**23/01633/F - Site at Calthorpe Street and Marlborough Road Banbury. Demolition of existing retail units and public car park and redevelopment for residential dwellings (C3 Use), provision of private car parking, hard and soft landscaping and photovoltaic (PV) panels on roof, and associated works.**

The Banbury Civic Society wishes to express some grave concerns about the proposed development.

Client:
Tri7
Project:
Calthorpe Street, Banbury
Drawing Title:
Marlborough Road - Library Section
Drawing Status:
PLANNING

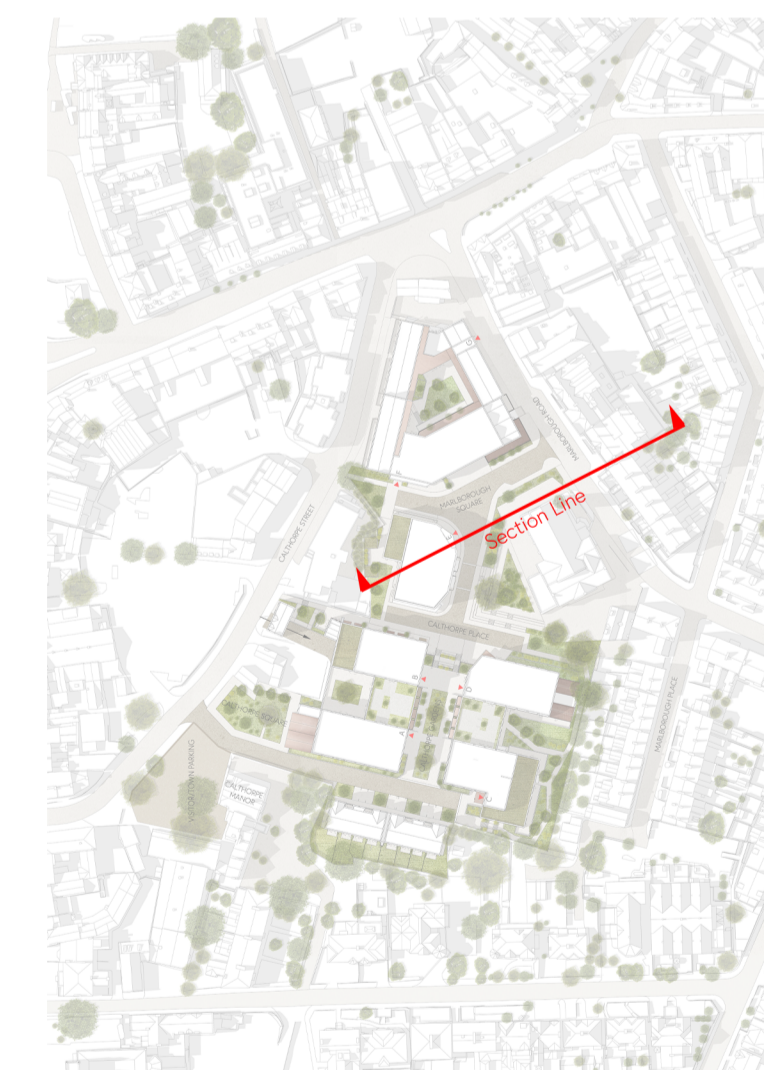
Whilst more sympathetically designed, the proposed 4-storey 'Victorian warehouses' proposed for the site perimeter are both over-scale for their location and of an inappropriate idiom, given the site's historically green and open nature. Such buildings would no doubt be suitable for Banbury's 'Canalside' industrial area, but they are historically inappropriate for this site and a poor substitute for the existing trees on the present margins of the site.

Client:
Tri7
Project:
Calthorpe Street, Banbury
Drawing Title:
Existing Site Sections 02
Drawing Status:
PLANNING

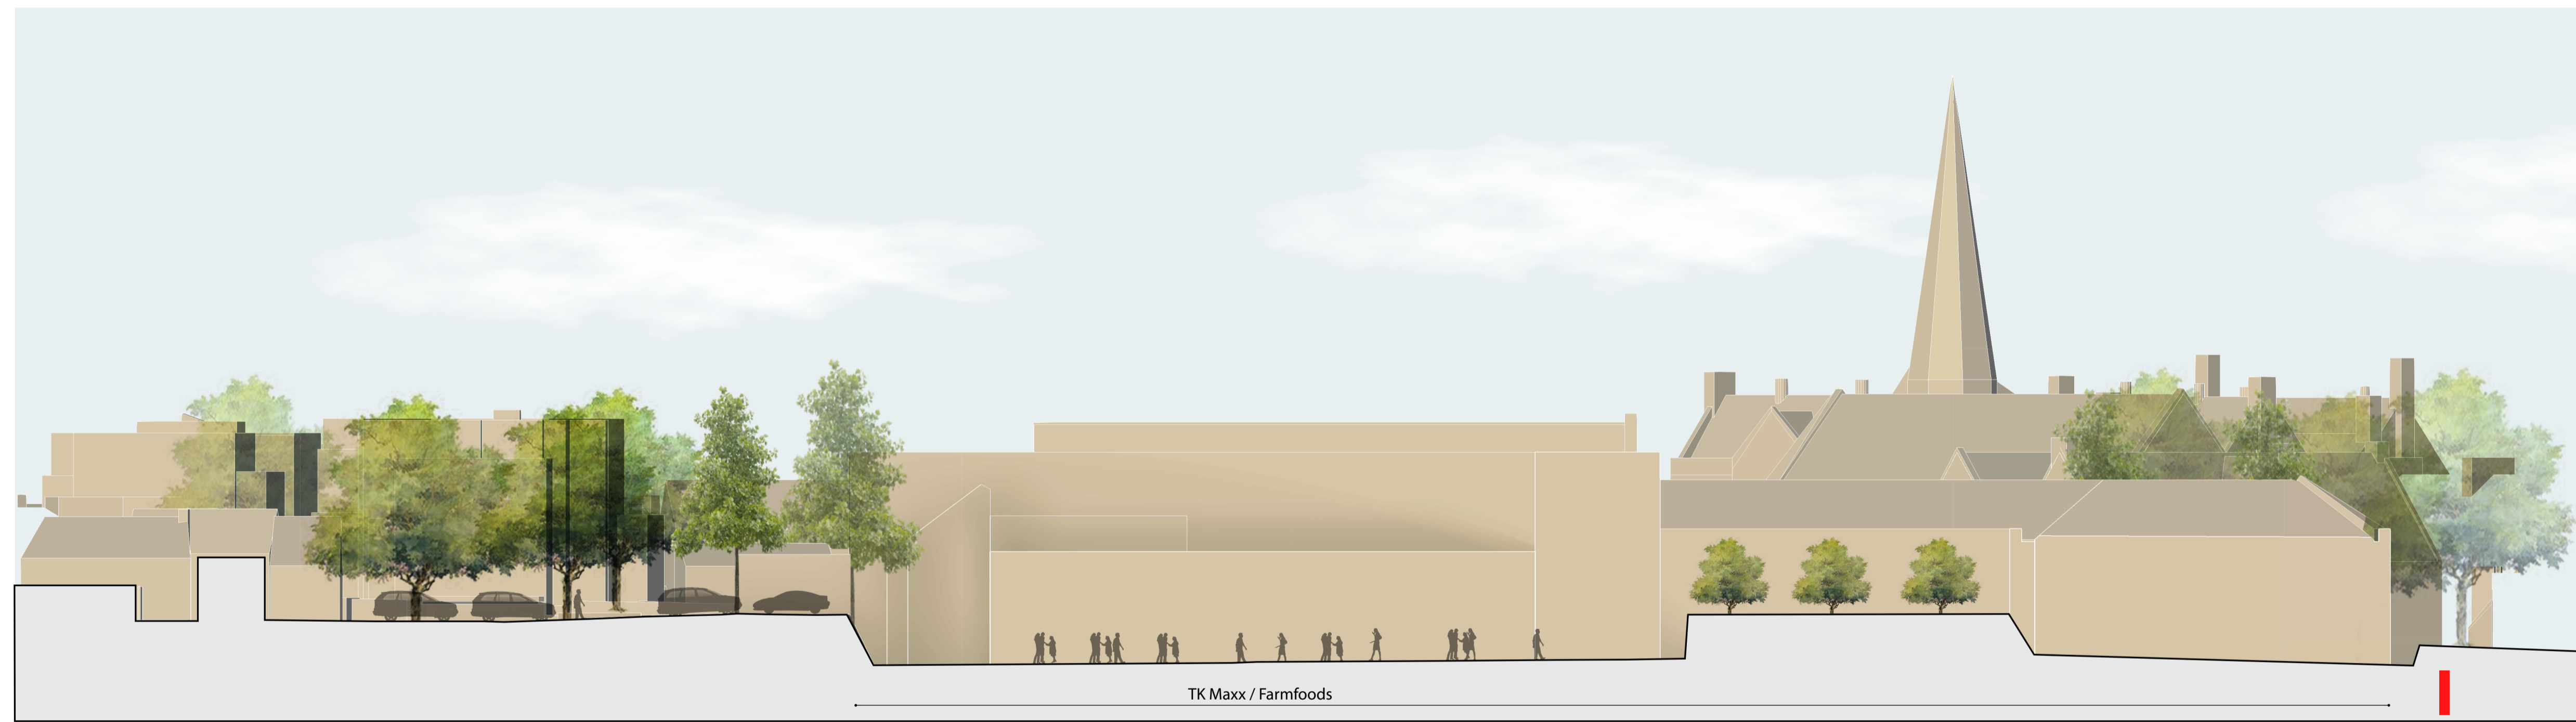
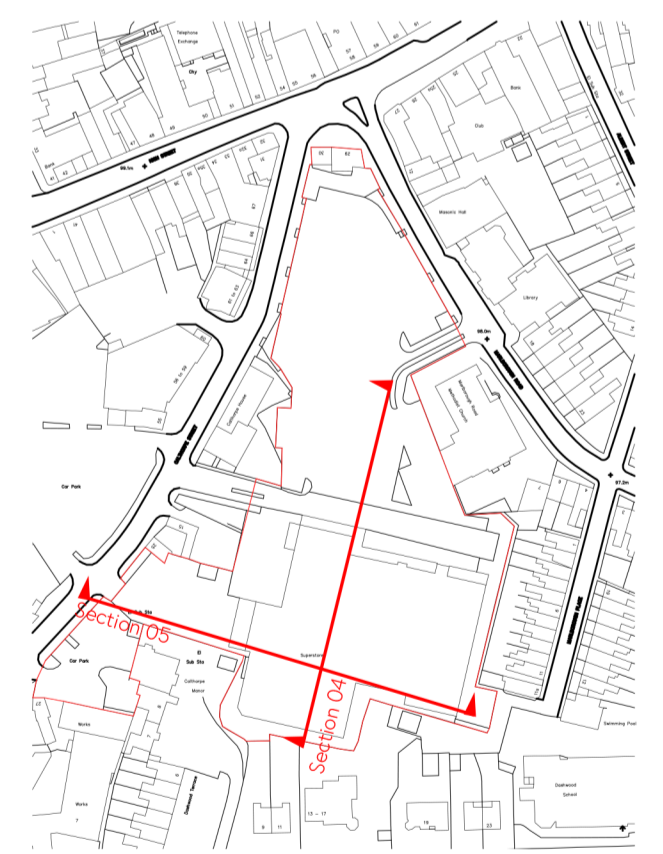
We also note that the northern half of the site is currently raised by up to 2.5m above pavement level, with retaining walls facing onto both Marlborough Road and Calthorpe Street. The submitted plans shown the new buildings at pavement level, introducing a further substantial cut-an-fill imbalance.

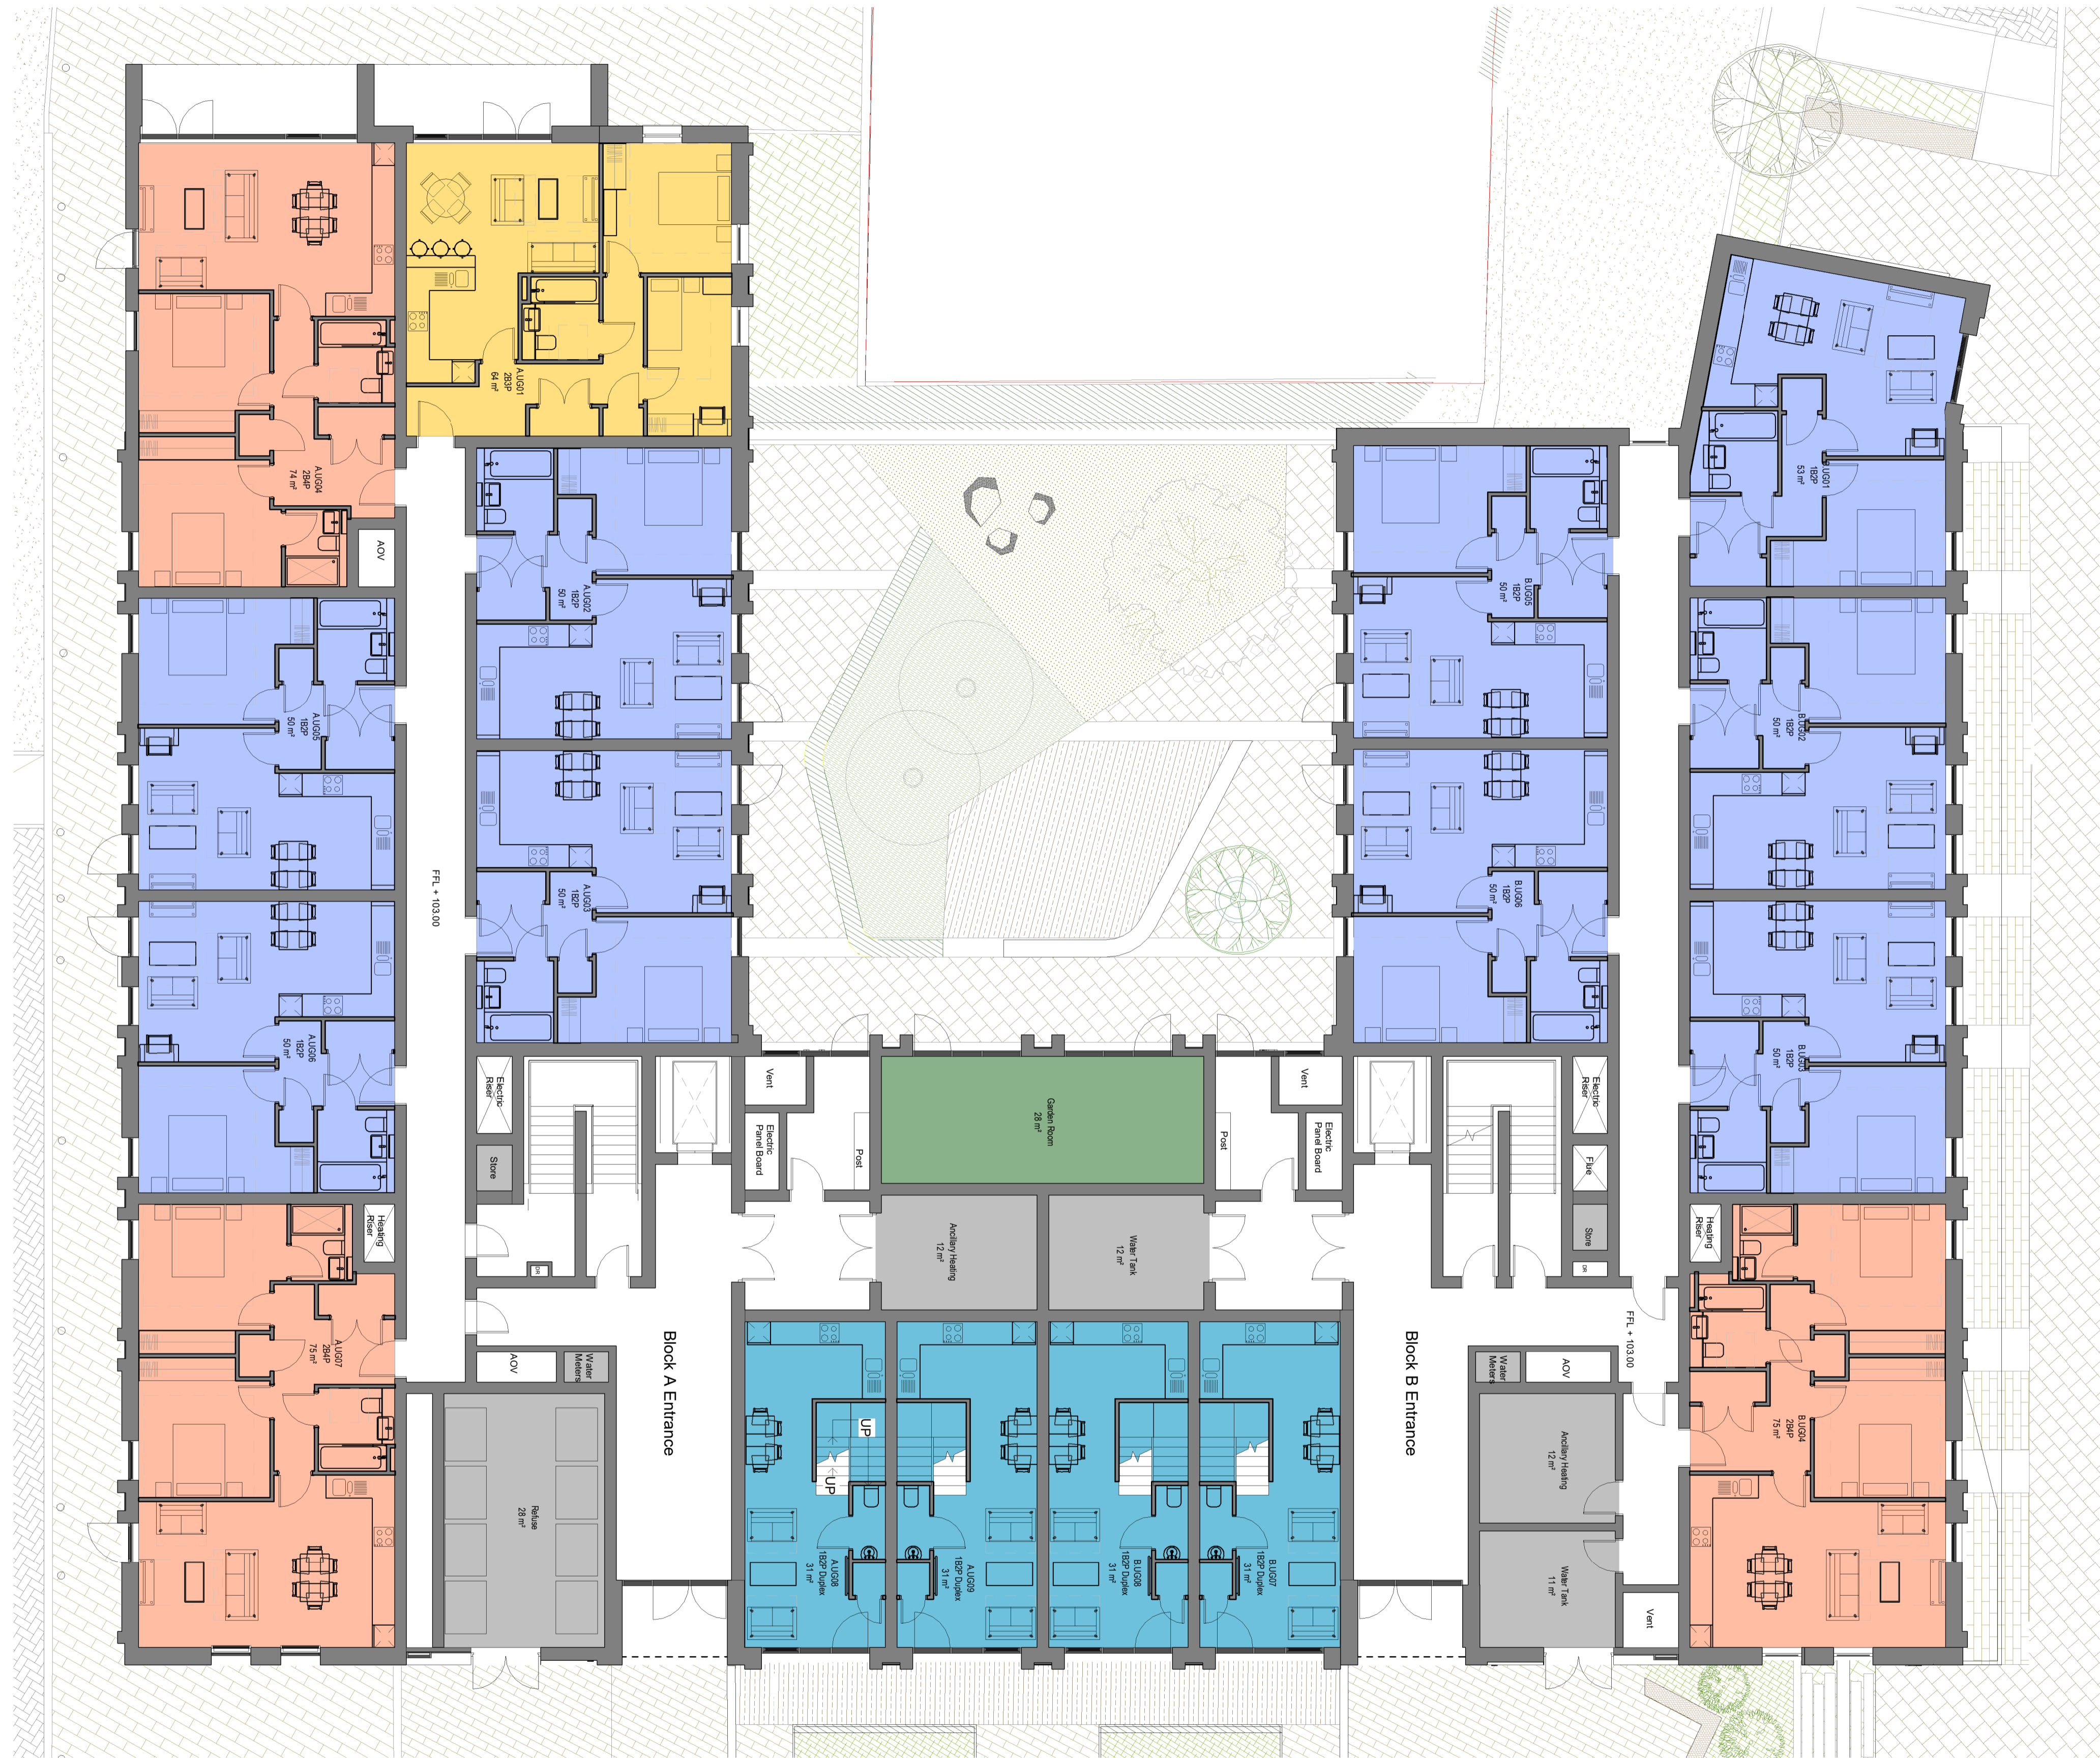
- *Block A would have some impact on the significance of the Grade II\* Danvers House (Calthorpe Manor), as it would bring larger buildings in close proximity to it, reducing the perceived sense of openness to the north of the house and competing with its prominence.*
